Inner Sydney high school
Response to Submissions - Architecture
NSW Department of Education

fjmt studio architecture interiors urban landscape community
04 October, 2017 - Document ref - Rev 01

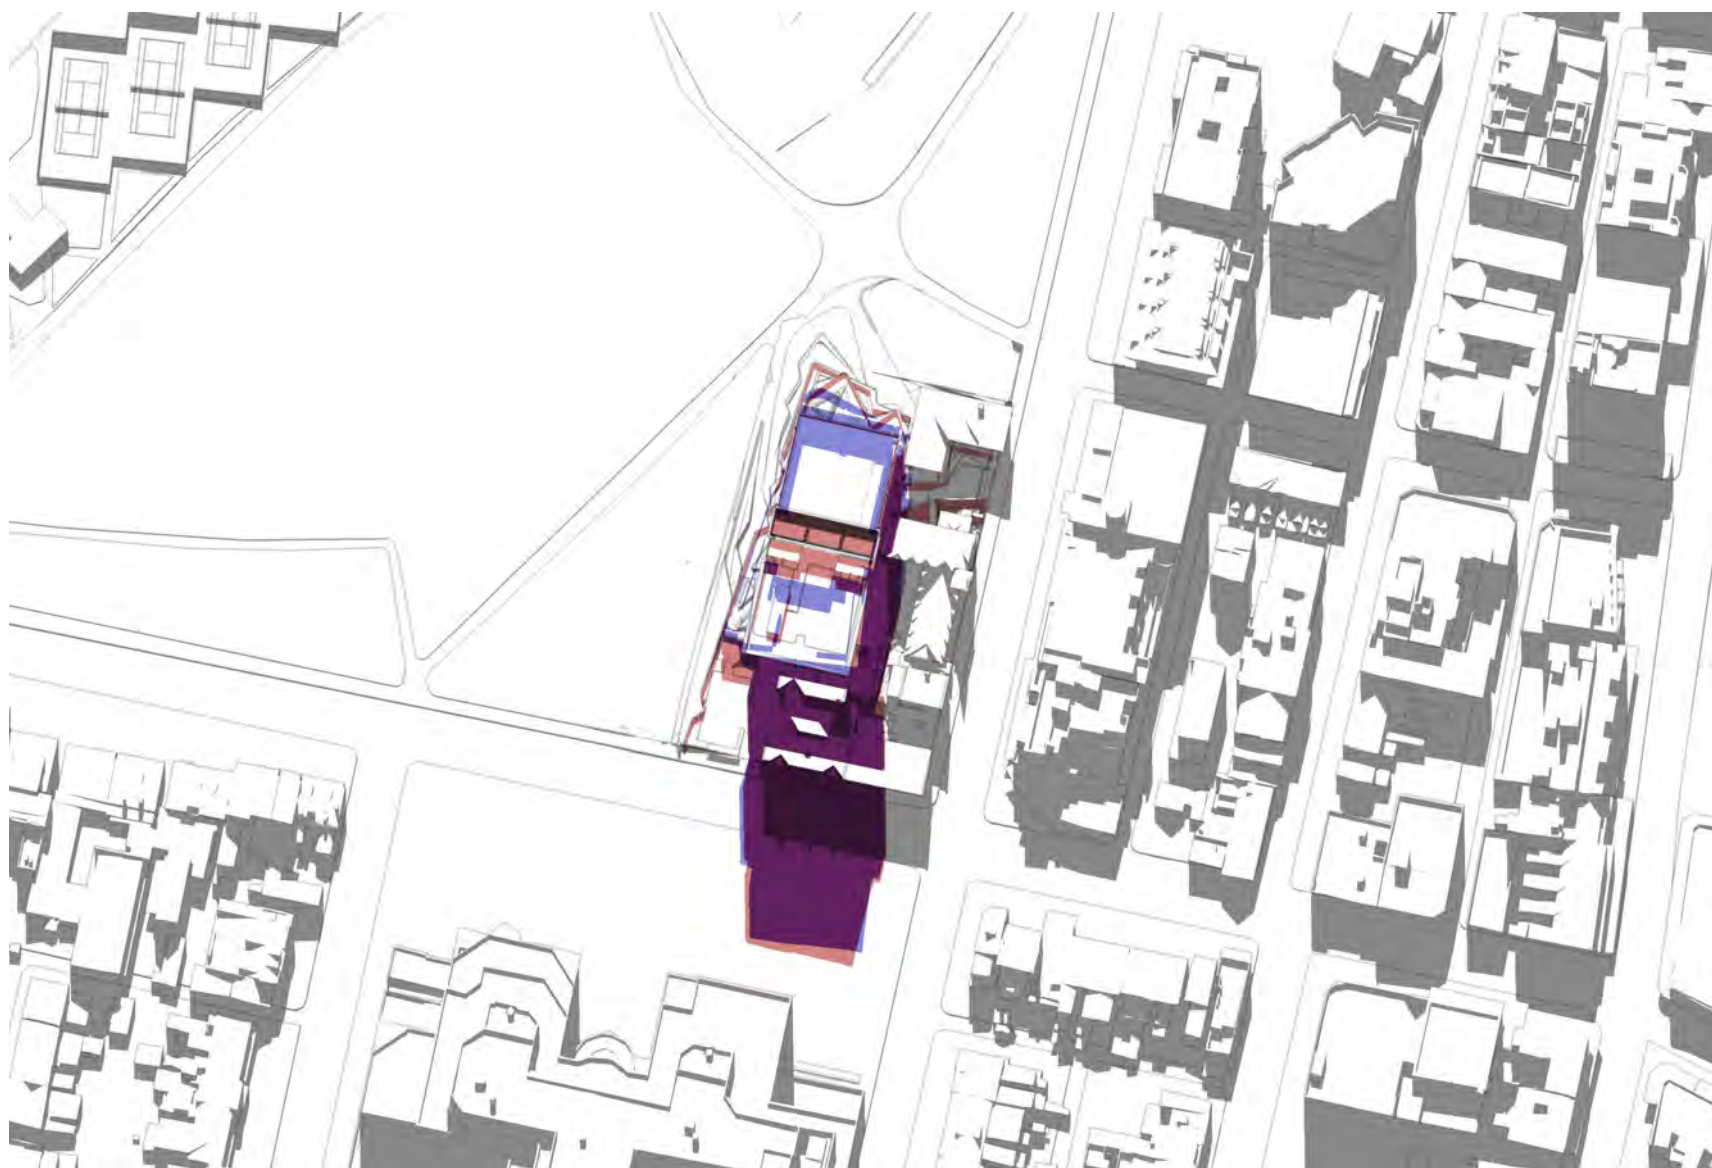
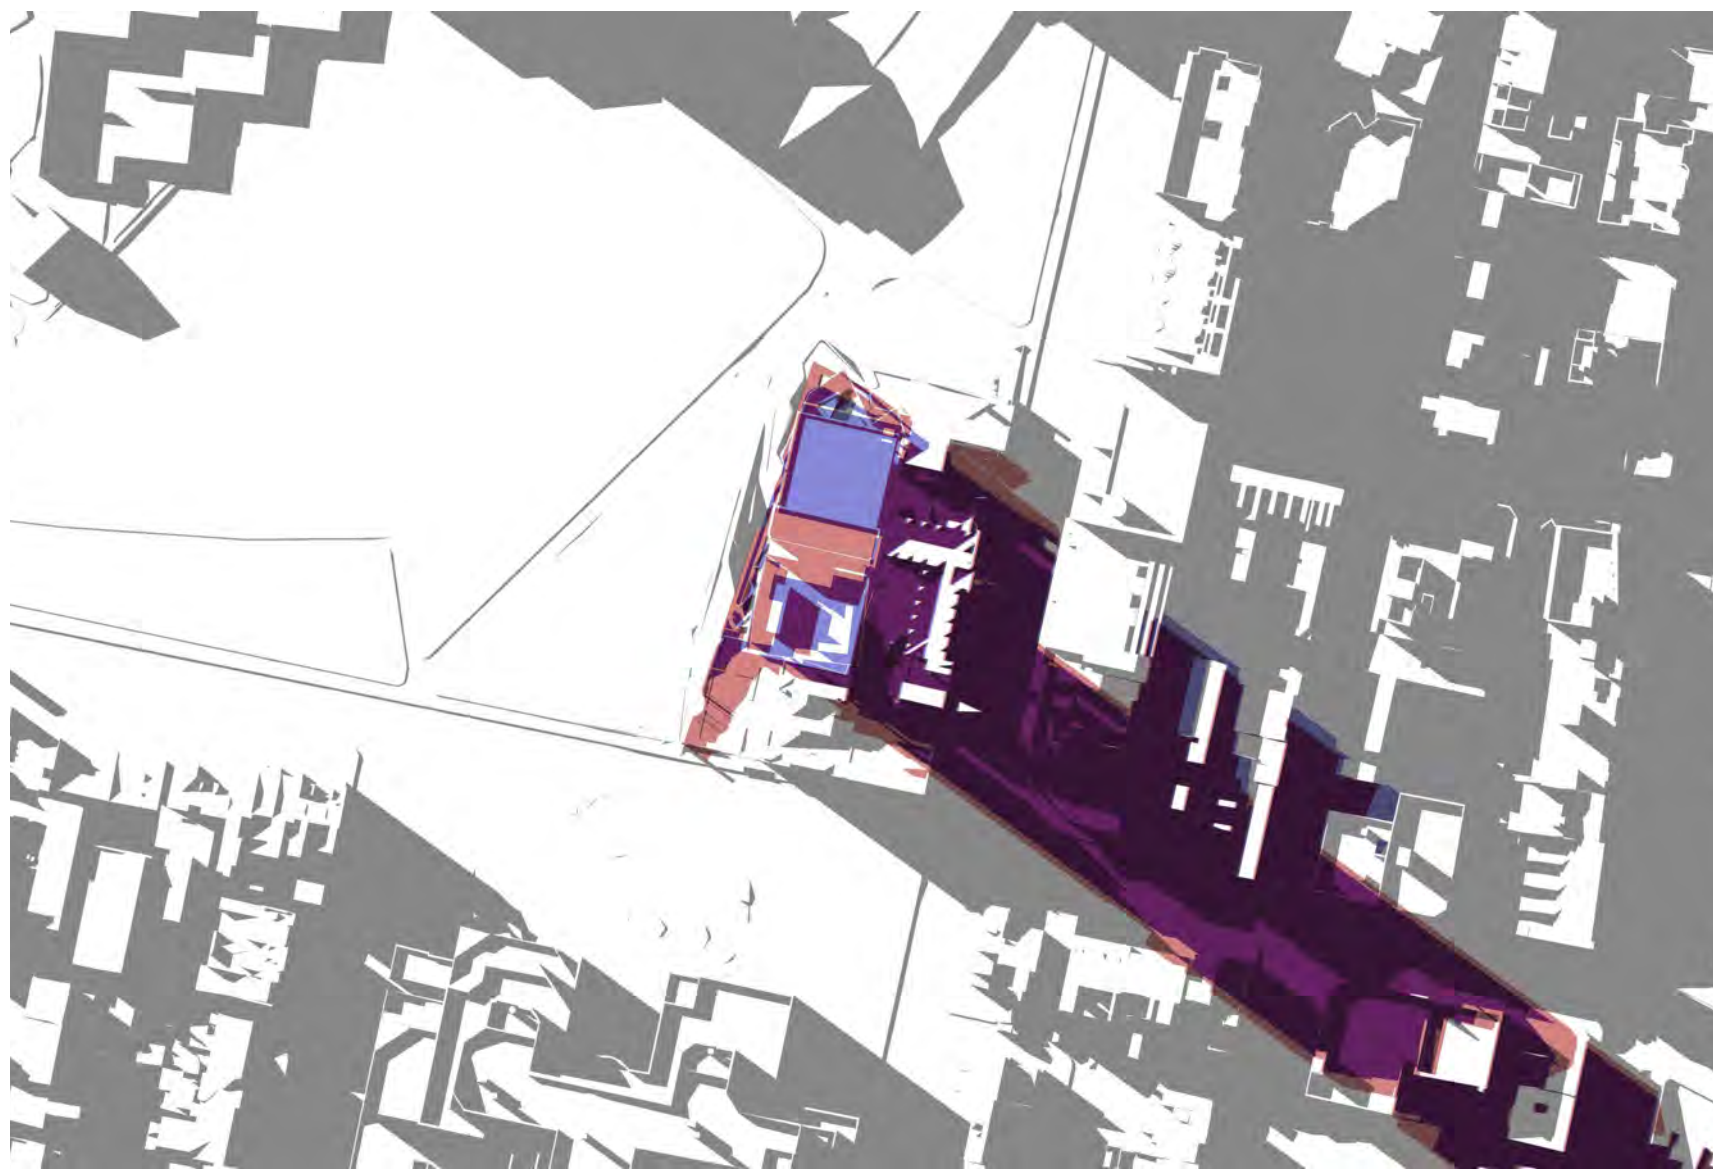
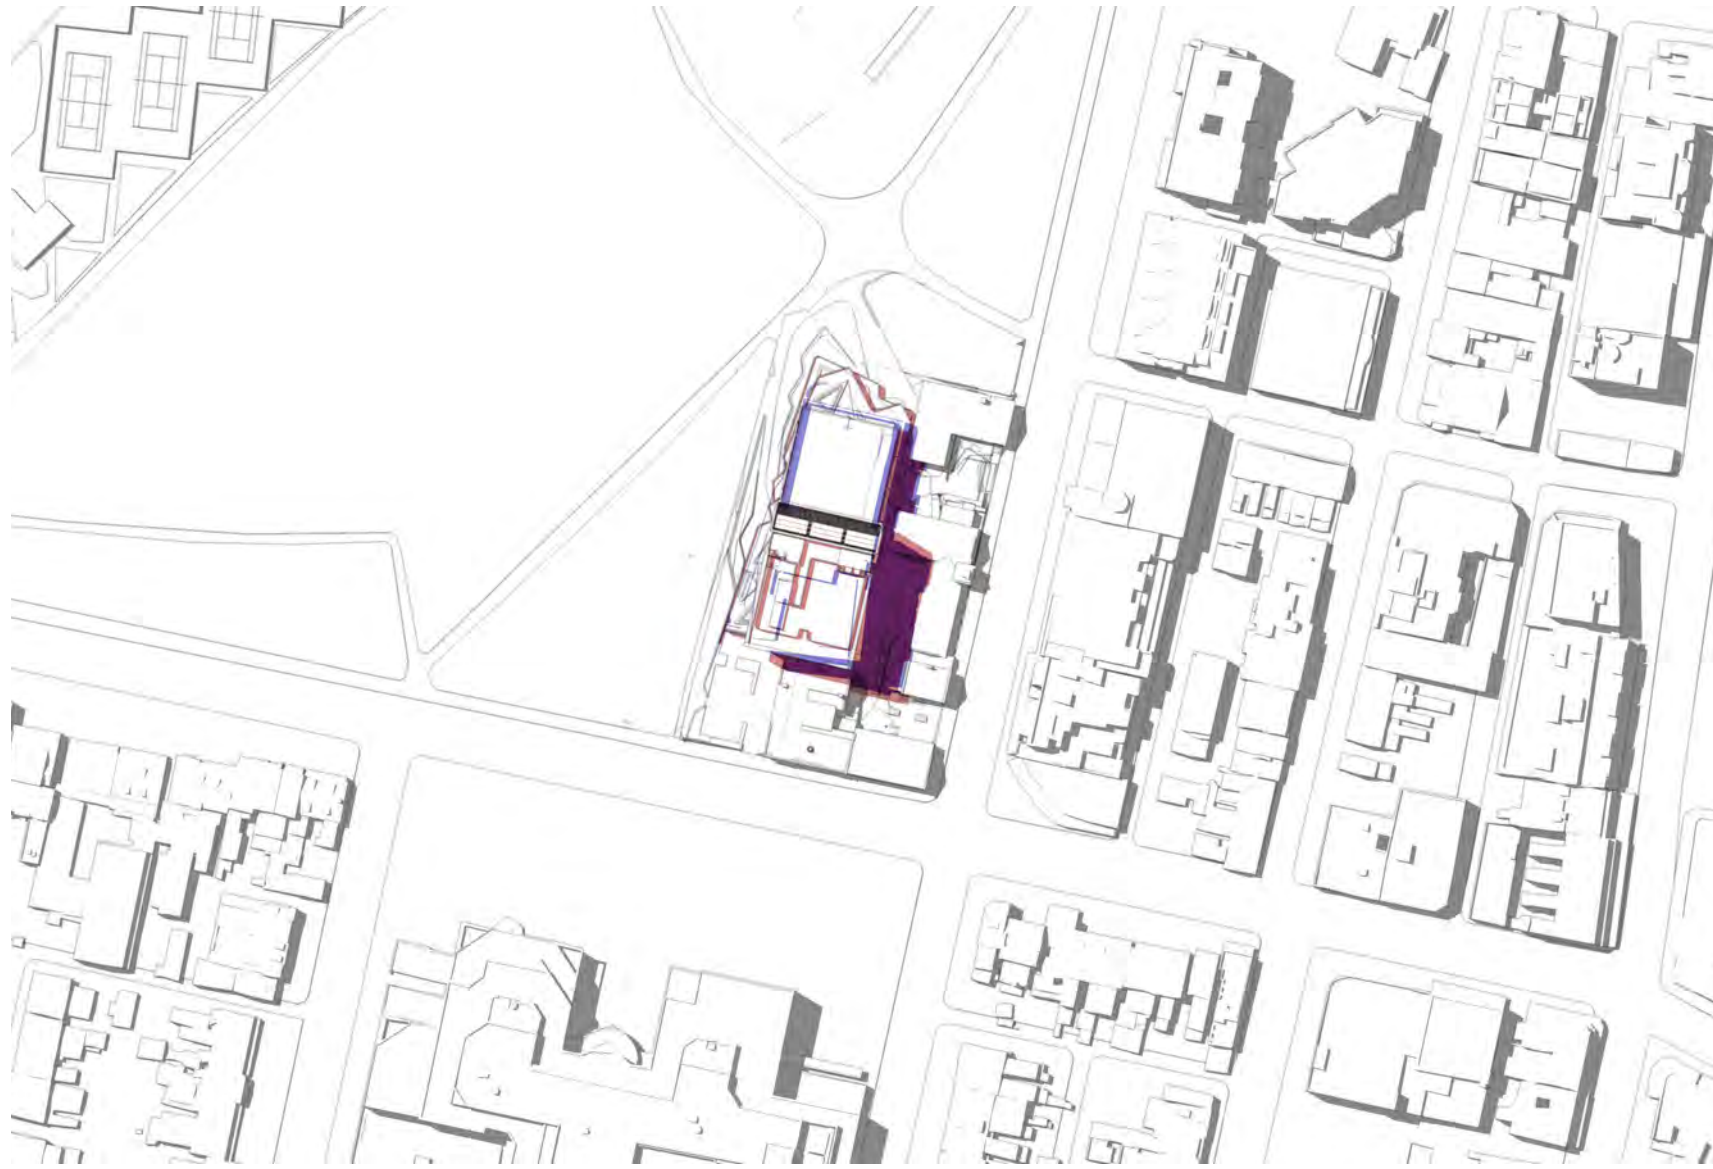
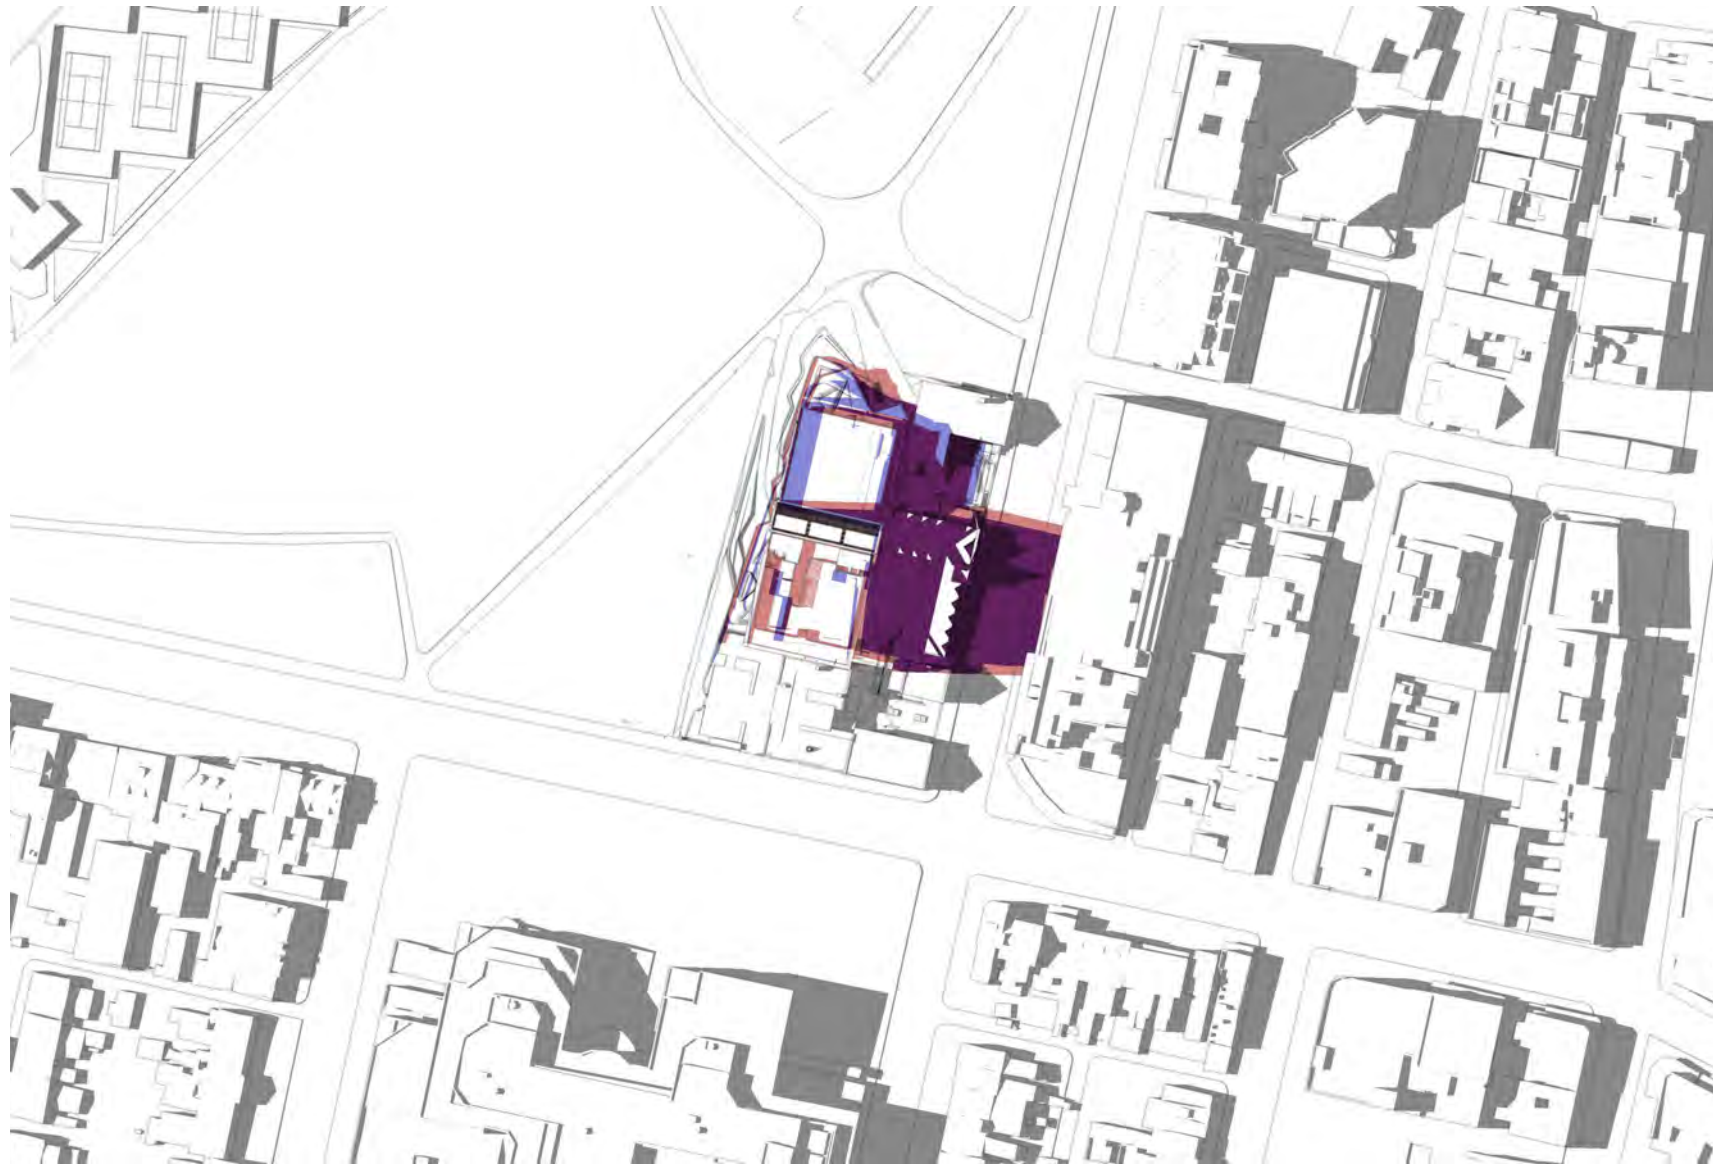
6	Urban Design and Design Excellence Overshadowing	
	There is a discrepancy in the material provided in relation to the shadows cast by the proposal. The <i>Shadow Impact Analysis</i> drawing on page 18 of the Architectural Design Statement (ADS) does not match the shadows shown on page 19. The City has had to assume that the analysis diagram would show 21 June.	Refer to the updated Overshadowing Diagrams which have been recast indicating the SSD Proposal, the revised RTS Proposal, Current and Context.
	The following is the City's analysis of both diagrams shown on pages 18 and 19, which are of interest:	Note
	The proposal creates a minor shadow to Prince Alfred Park between 9-11am.	With the new proposal there are generally improvements.
	Larger properties located to the east of the site which have west facing openings will be impacted by the proposal. These properties rely on solar access from 1-3pm (we have discounted the midday sun angle as it is too oblique to the facade to be of any substantial effect.) These properties include: - 204-214 Chalmers Street (impacts to 12 apartments facing west onto Chalmers Street and communal roof terrace) -188 Chalmers Street (potential impacts to those apartments located to the south of the Chalmers Street facade at 3pm).	Please find attached solar access diagrams which provide an analysis of the proposals impact on the facades of the existing residential buildings. The updated proposal has minimised the impact through the lowering of the Studio.
